CITY OF ALBUQUERQUE

August 18, 2020

Re: Overture Senior Active Adult (BP-2019-04288)
6451 Palomas Ave NE (Area 3)
30-Day Temporary Certificate of Occupancy
Transportation Development Final Inspection
Engineer's/Architect's Stamp dated 3-26-20 (AA)(DRB) (D18D056A)
Certification dated 8-10-20

ENGINEER'S SEAL RONALD R. BOHANNAN P.E. #7868	OVERTURE SENIOR ACTIVE ADULT	DRAWN BY DY
	SITE PLAN FOR BUILDING PERMIT	DATE 3/02/2020
	TIERRA WEST, LLC 5571 MIDWAY PARK PLACE NE ALBUQUERQUE, NM 87109 (505) 858-3100 www.tierrawestllc.com	2017086-SPB
		SHEET # C1
		JOB # 2017086

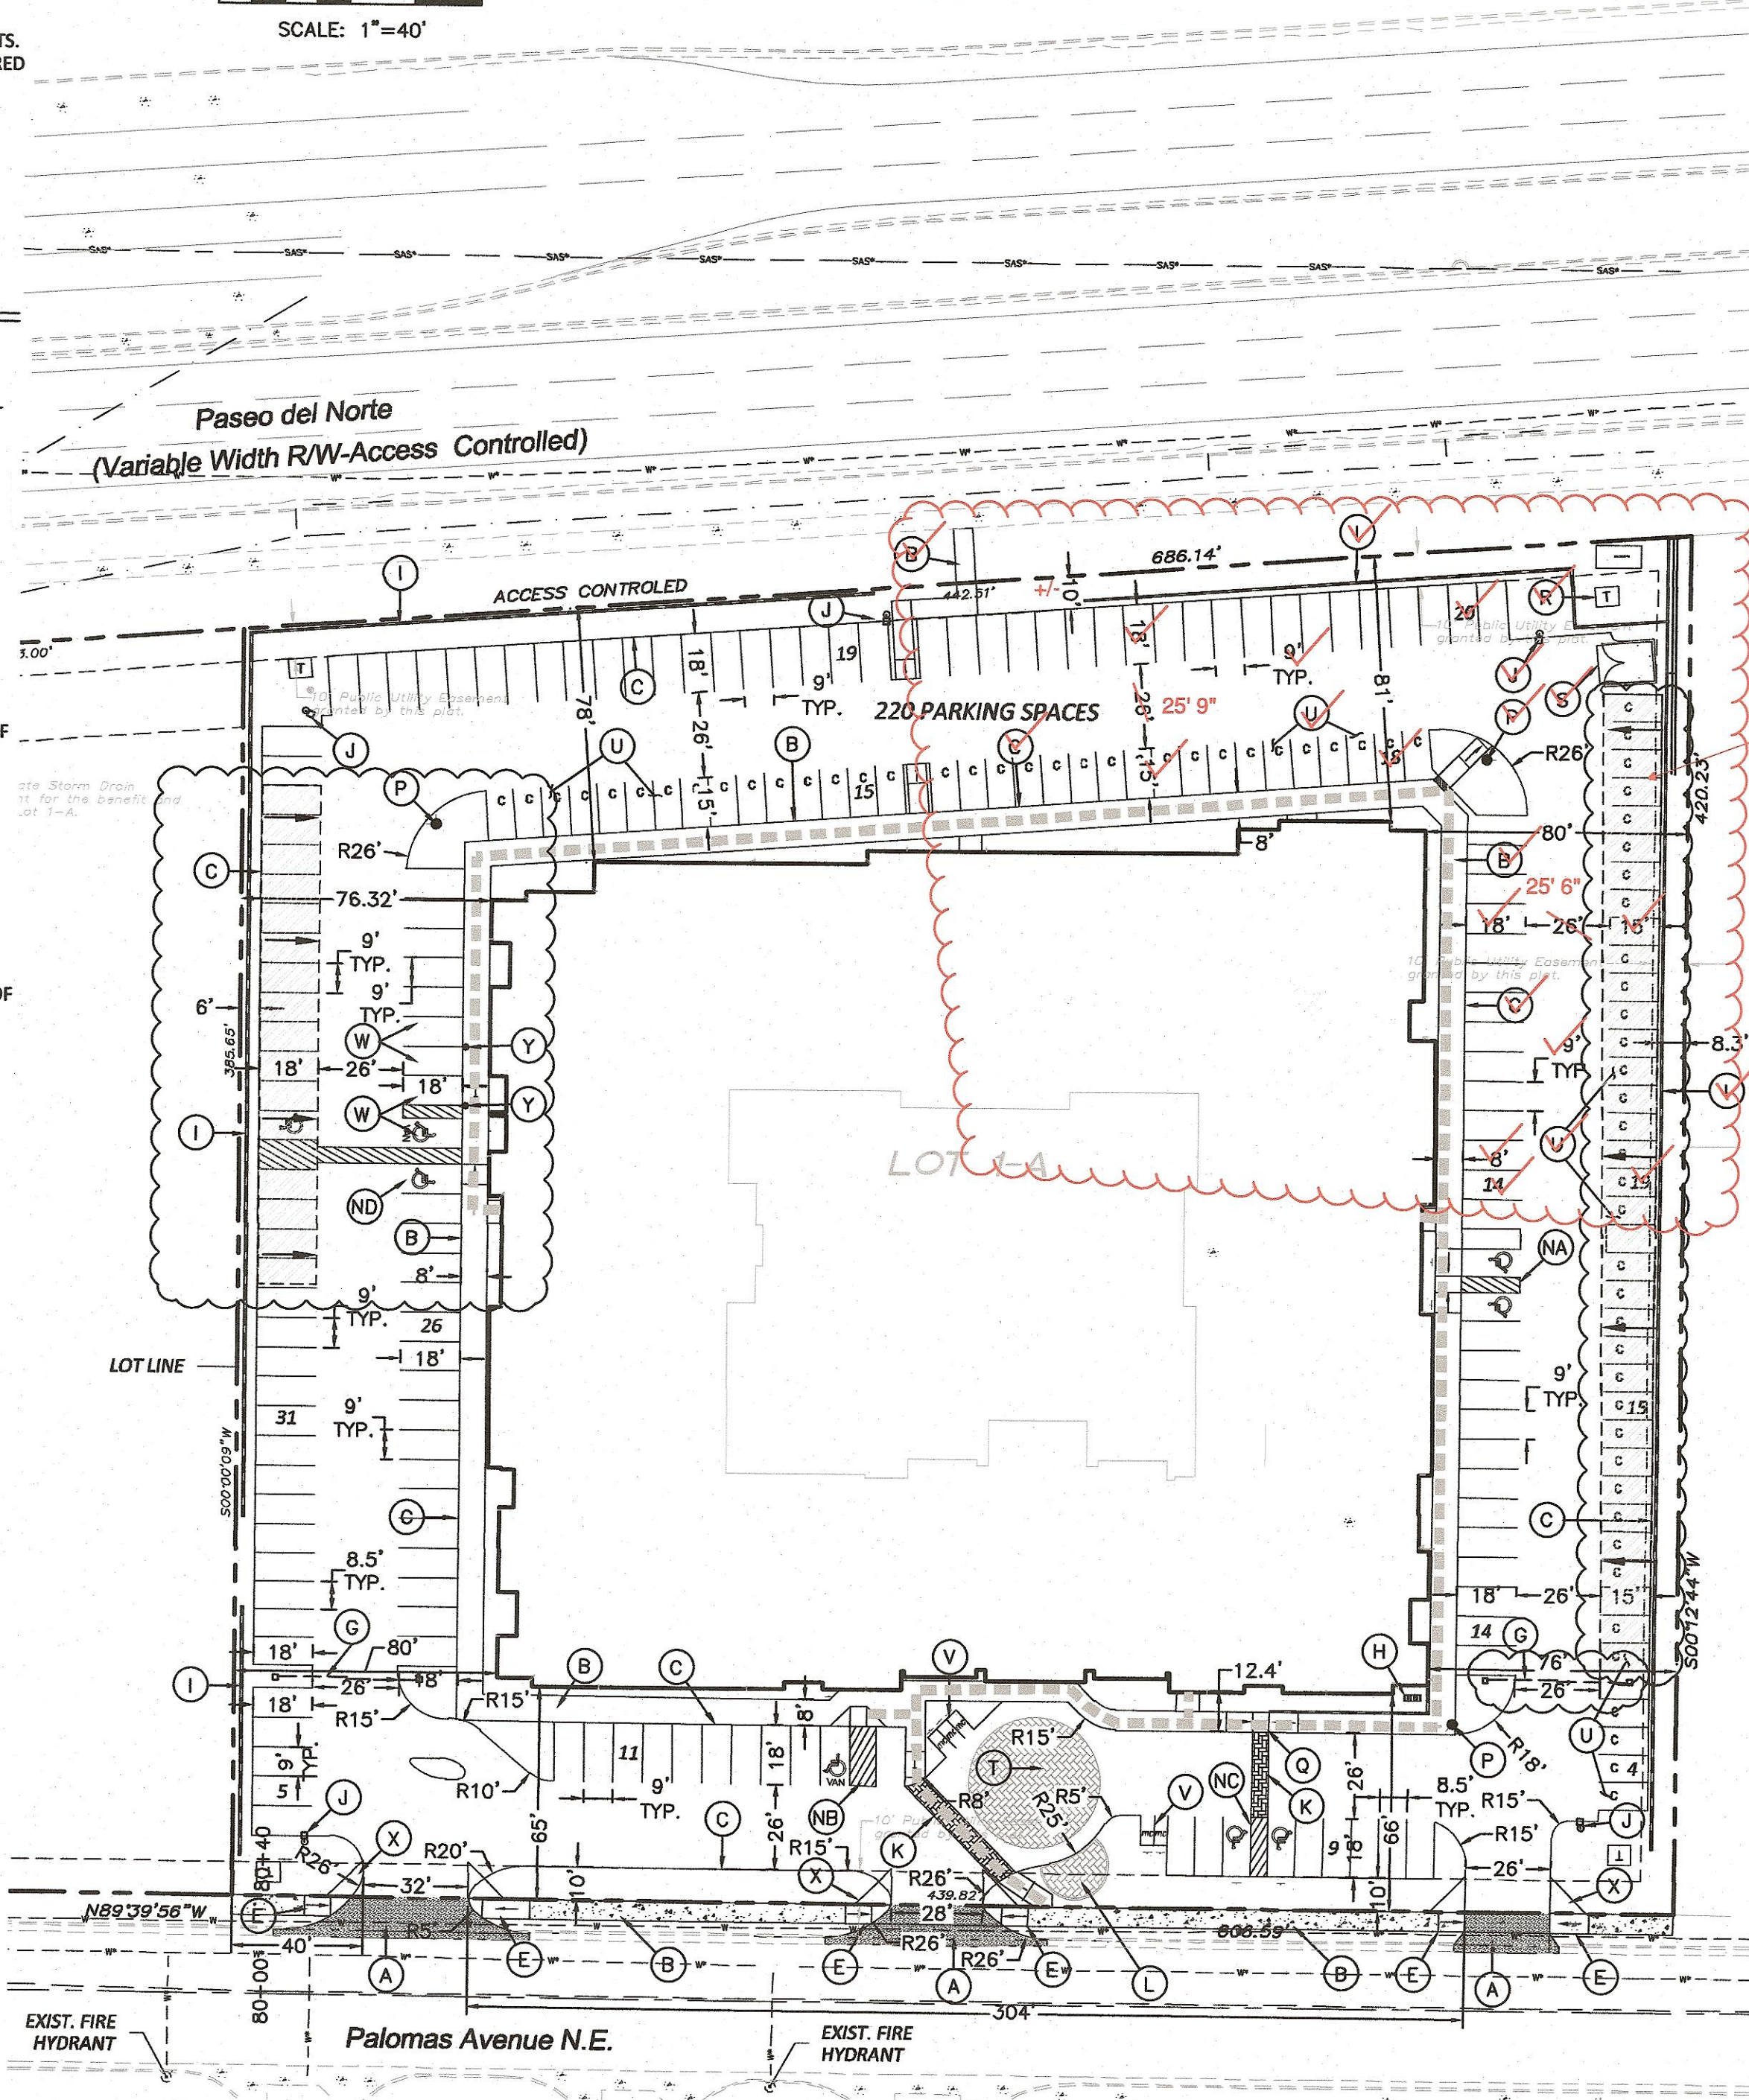
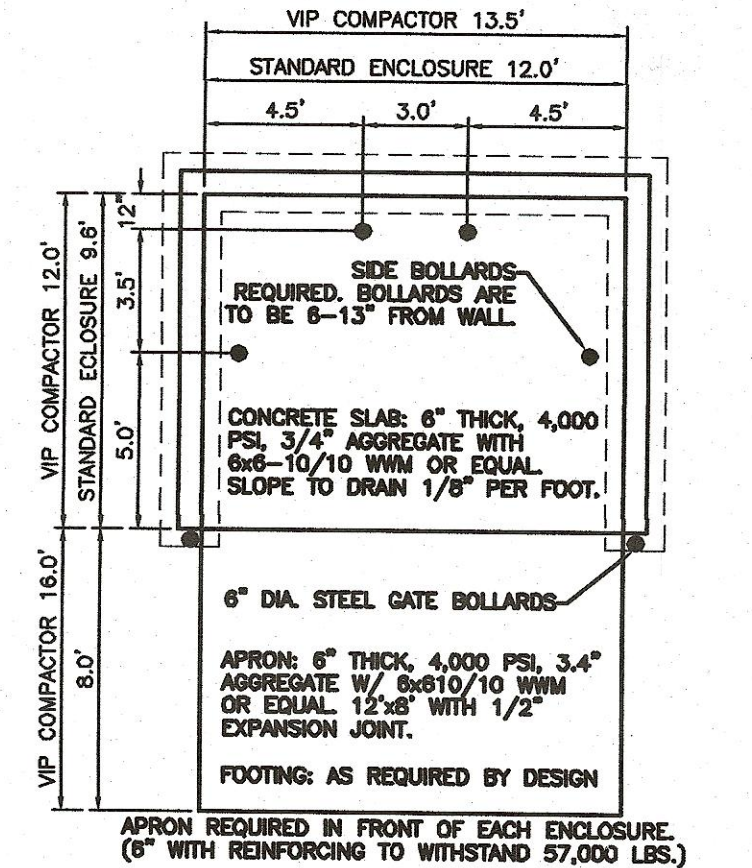
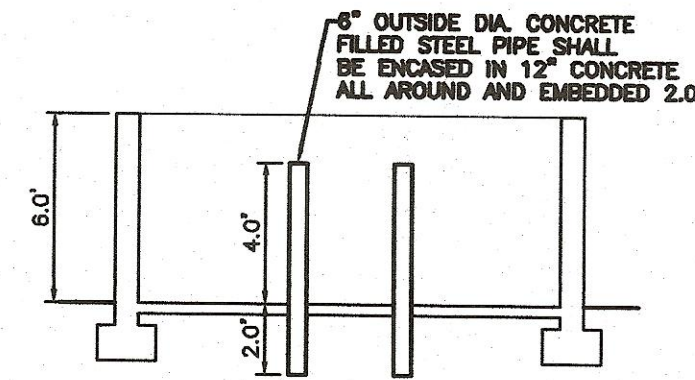
- Please complete covered parking structure
- Please relocate deleted ADA stall.
